Cove at Woodmore Attached Single Family Development

Subject: Northbay at Lake Woodmoor, SF-16-021, Review 1

**EL PASO COUNTY PLANNING AND COMMUNITY DEVELOPMENT DEPARTMENT**

SHEET
13
13 of 18 Sheets

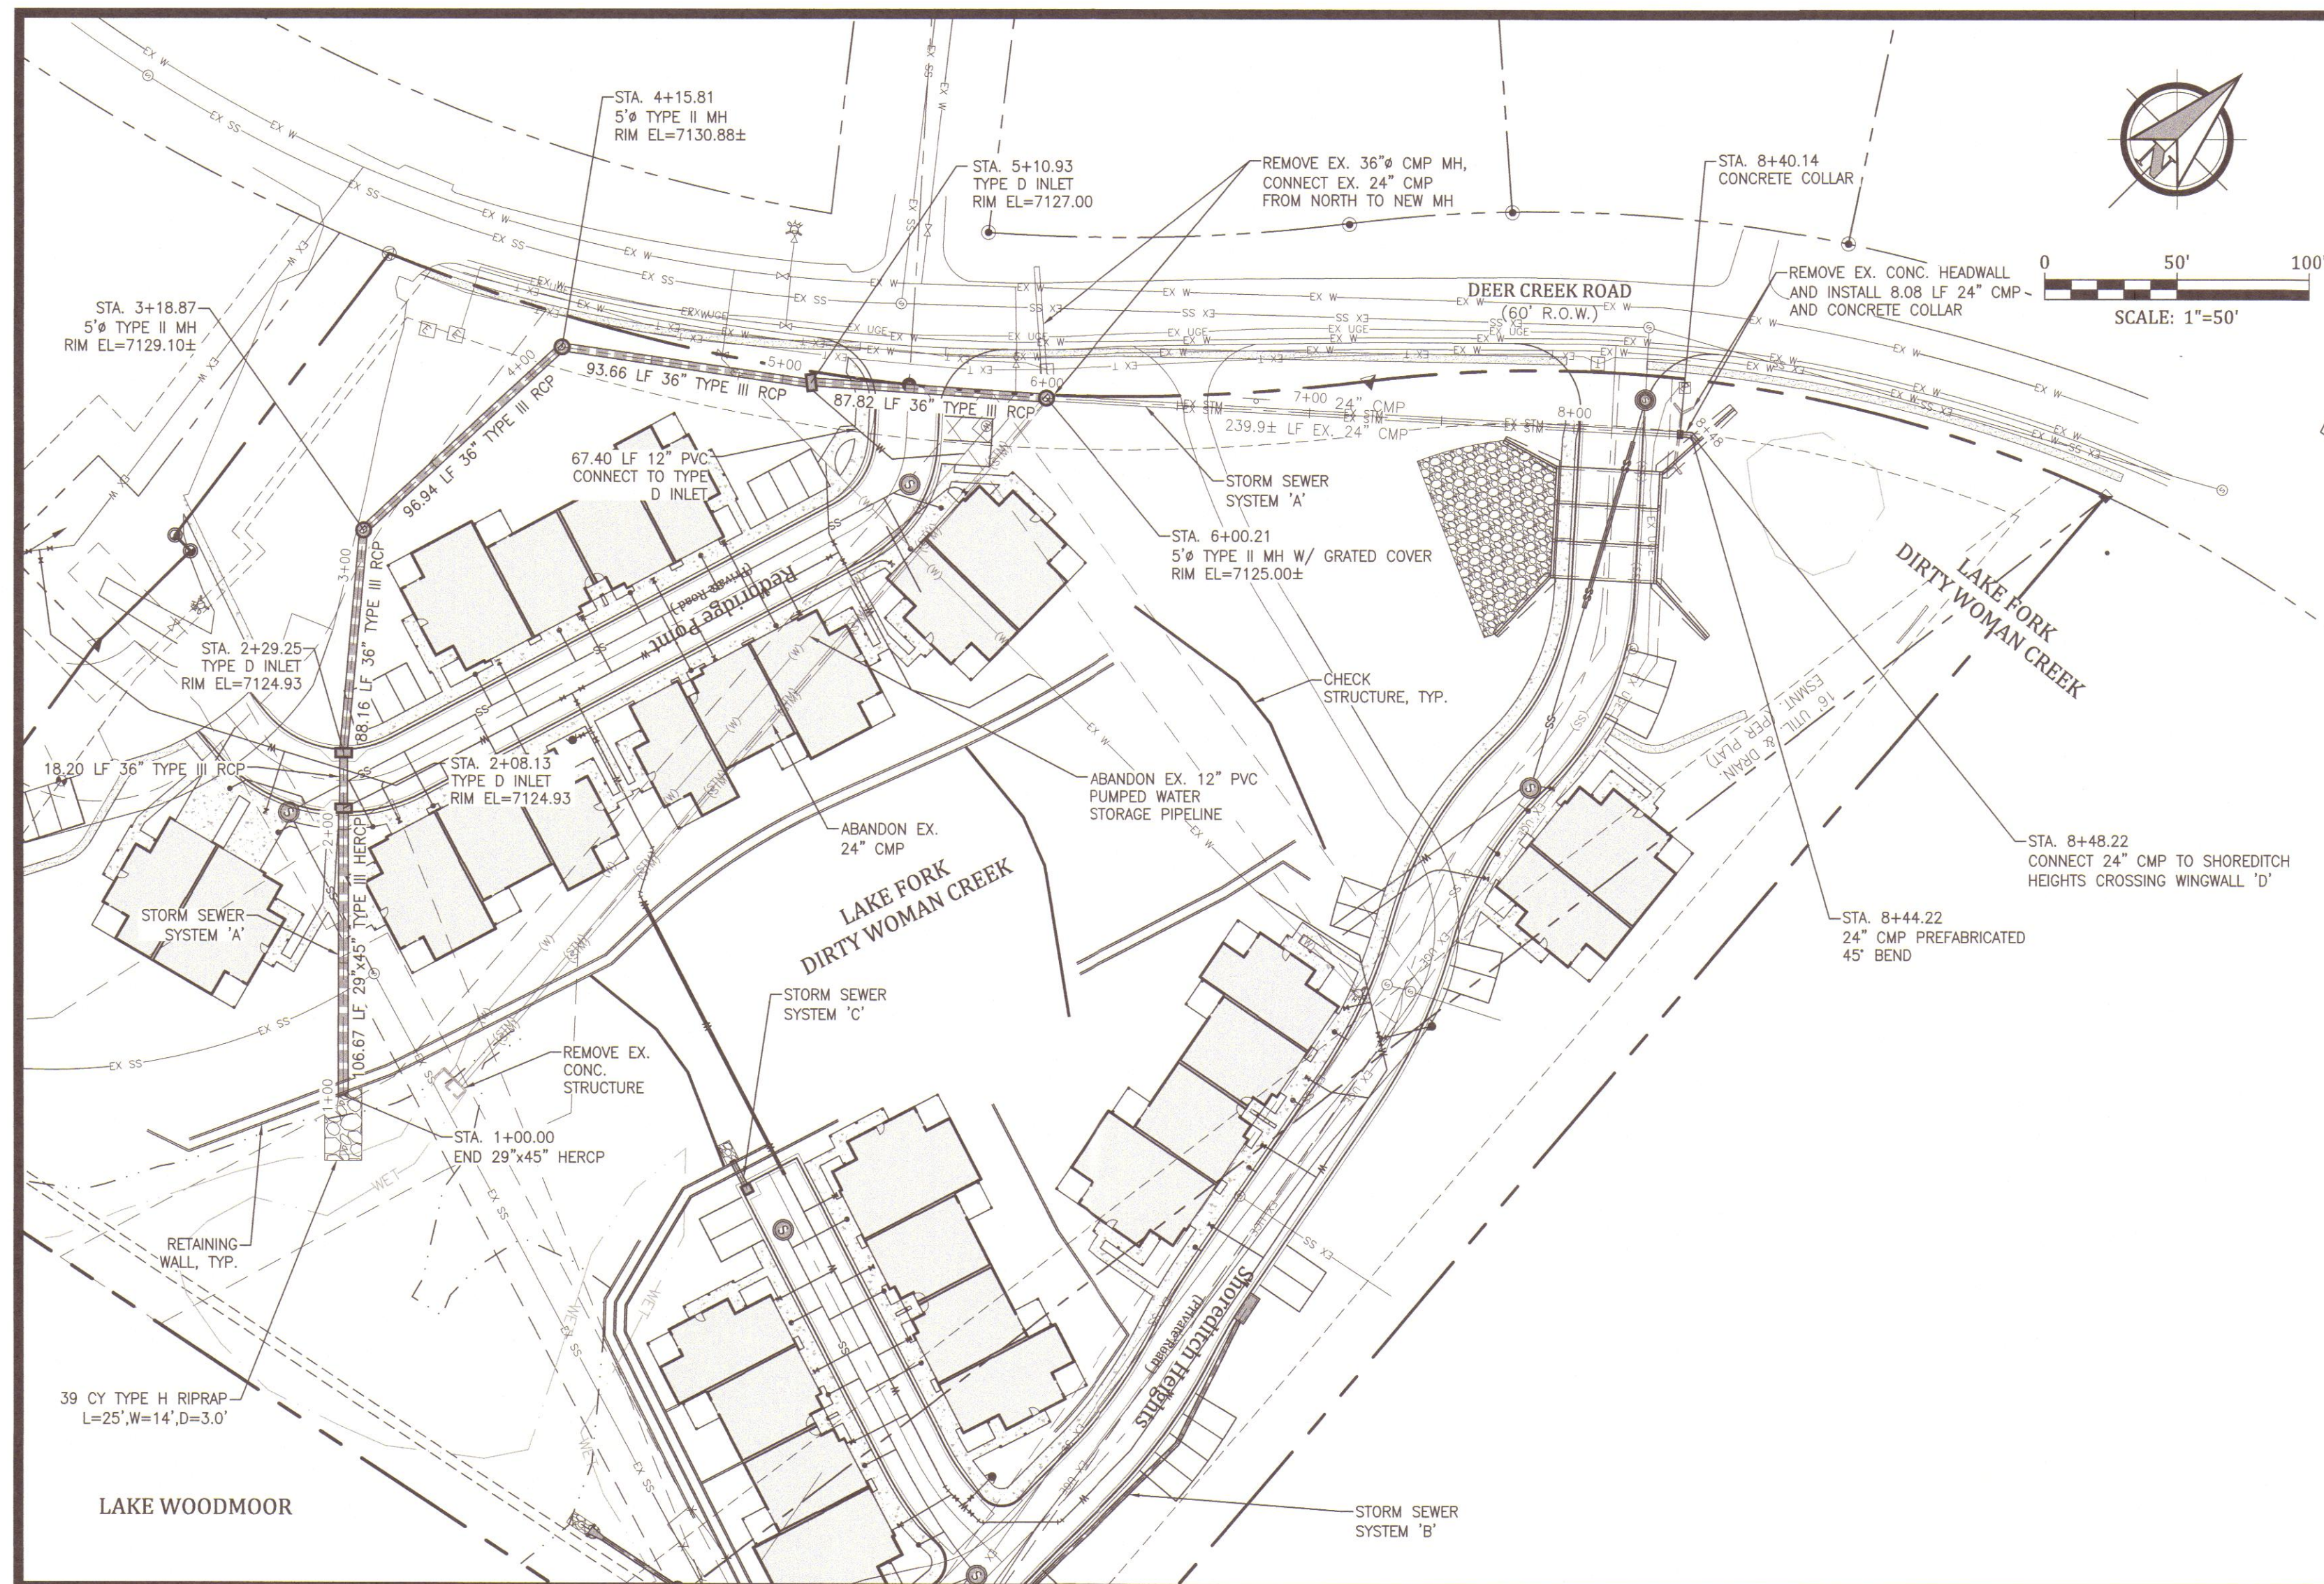
6. HEC-RAS calculation comments:
  - a. Provide an exhibit (plan view) showing the HEC-RAS cross section locations. Additional cross sections may be required.

- b. The summary table for the proposed condition shows sections of the channel exceeds the DCM permissible mean velocity for native grasses (DCM Table 10-4). Froude numbers are also at critical or supercritical. Per DCM 10.7, the channel should be designed for Froude numbers less than 0.9. Update the channel design to comply with the DCM for open channel design. Alternatively, conduct shear stress calculations and see if the results are within the allowable shear for native grass. Typical allowable shear for long native grass are 1.2 – 1.7 lb/sf and short native and bunch grass are 0.7 – 0.95 lb/sf. See HEC No. 15.

- c. Adjust the manning's n value going through the culvert (RS=783) to 0.013 for concrete.
  - d. The overbank n value should be smaller at the retaining wall areas since the material is concrete.

- e. Provide a narrative summarizing the results of the HEC-RAS calculation.
  - f. Evaluate the channel bend stability and additional freeboard at the bend because of superelevation. Will there be local scouring at the pocket area to the west of the channel bend near station 6+50 to 7+00? Additional protection may be needed downstream of station 7+21.
